**Response
by the
Royal Society for the Protection of Birds**

**Planning Application for construction of the Able Marine Energy Park on the
South Bank of the River Humber at Immingham, North Lincolnshire**

**Planning Inspectorate Ref: TR030001
Registration Identification Ref: 10015550**

Figure 28-1 Cherry Cobb Sands site layout

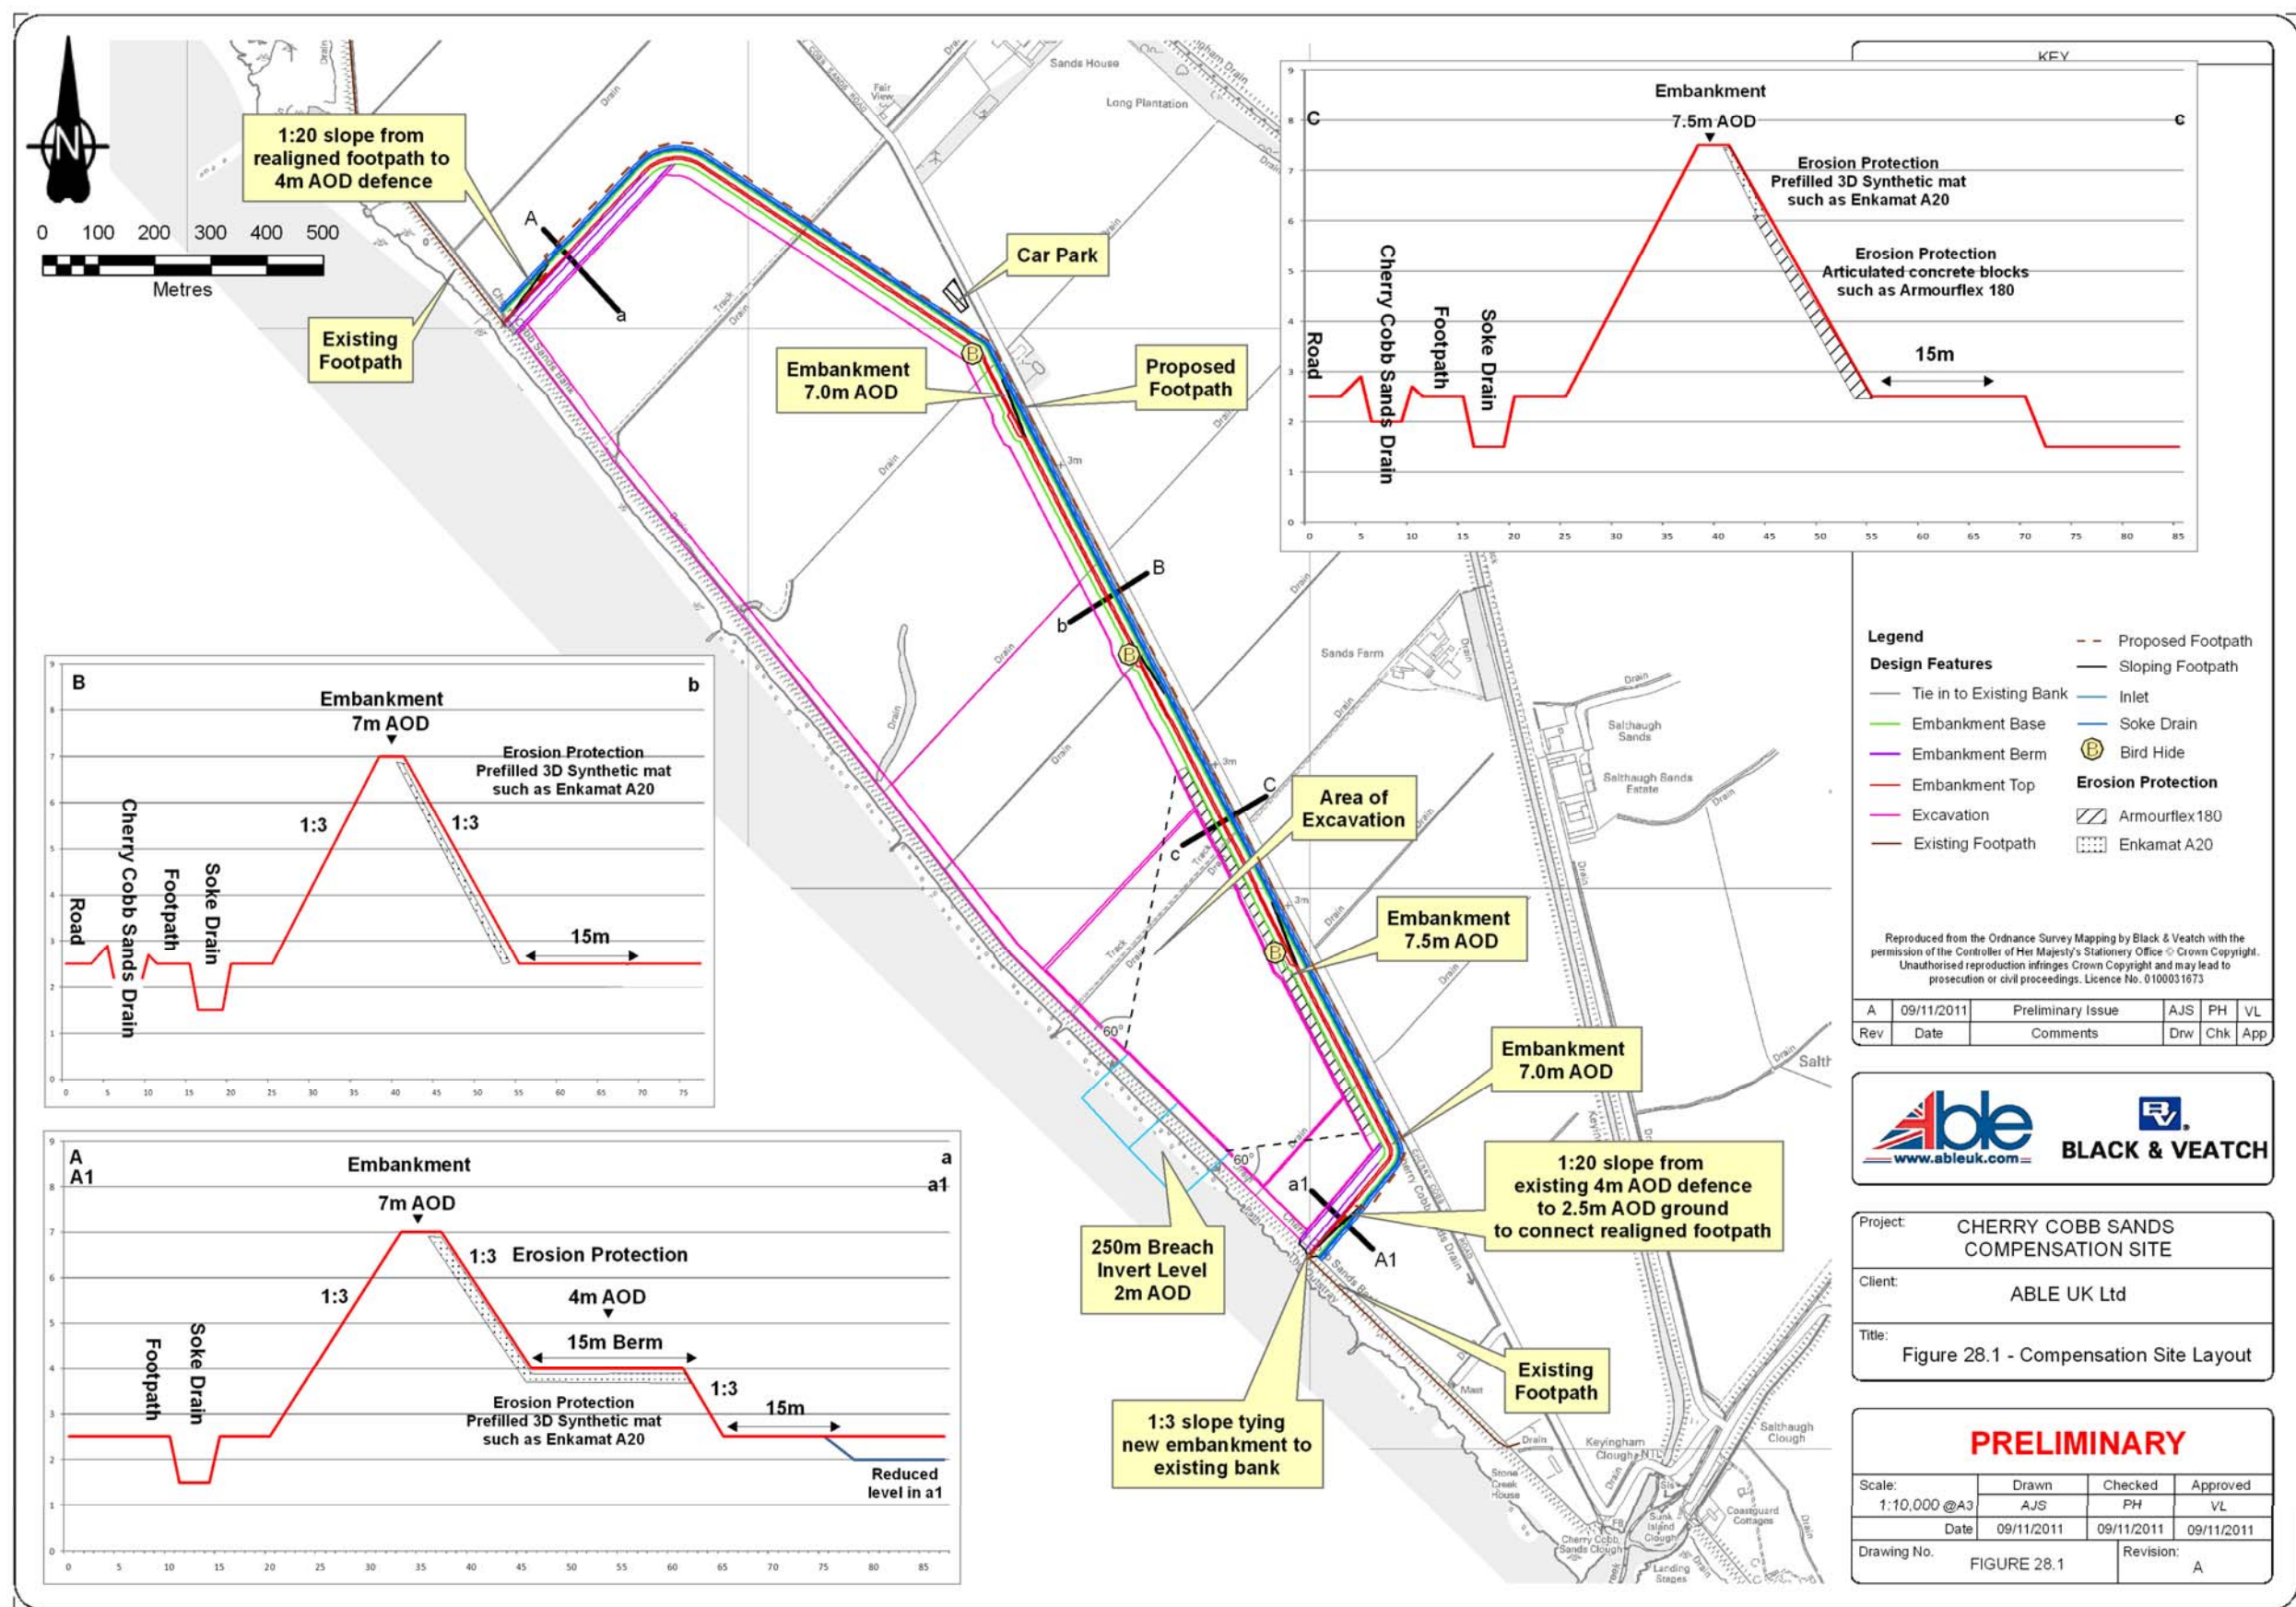
- d. Applying the Applicant's own data sets as explained in Annex III, the inescapable conclusion is that the vast majority of the Compensation Site will develop into saltmarsh under the current proposals within 7 years. The RSPB's analysis of the Applicant's data demonstrates that at best (non-precautionary approach) there will be between 16.1 and 21.4ha of intertidal mudflat after just five years.

Figure 28-3 Estimated ground levels at Cherry Cobb Sands after five years

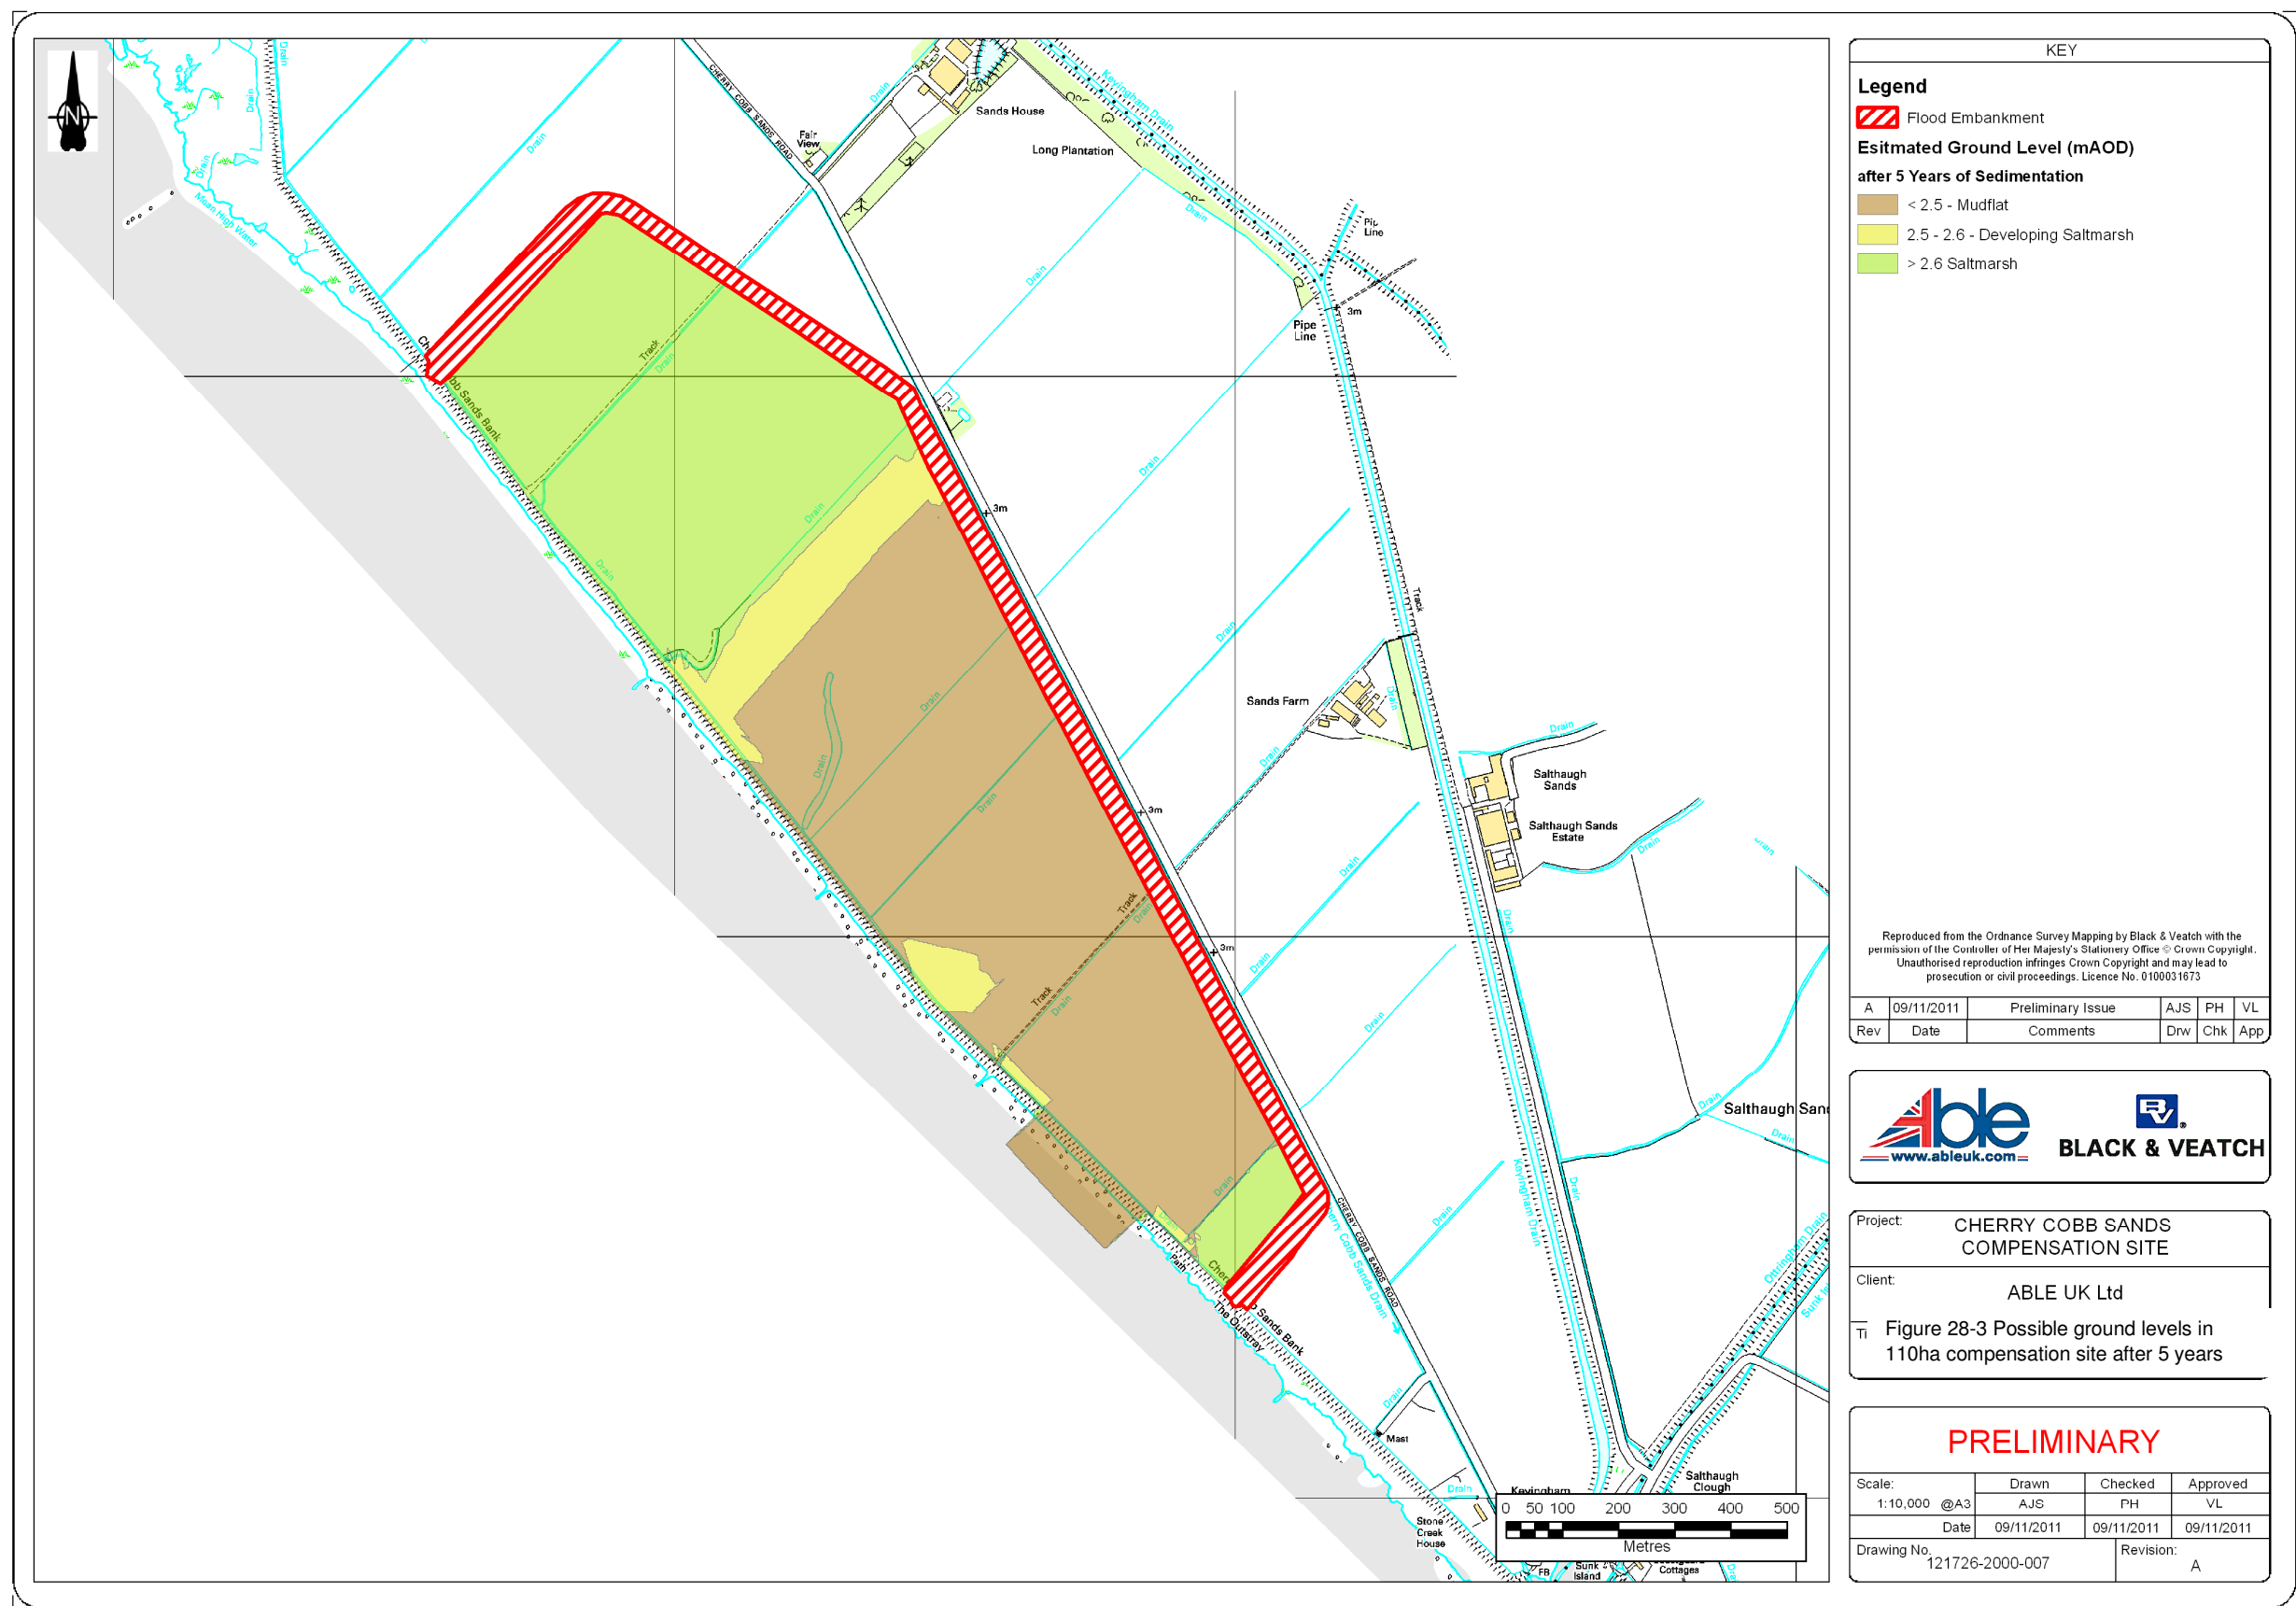
- c. The modelling on the extent and rate of accretion is, of course, highly dependent on the height of the boundary between saltmarsh and inter-tidal mudflat. For the reasons given in Annex III (attached), that level is here +1.9m AODN level - above that level there is not just the possibility but the certainty that saltmarsh will develop and that inter-tidal mudflats will not exist.

- f. In any event the Applicant modelling covers only a five year time frame. There is no evidential or scientific basis to assume that a stable state is reached in 5 years.
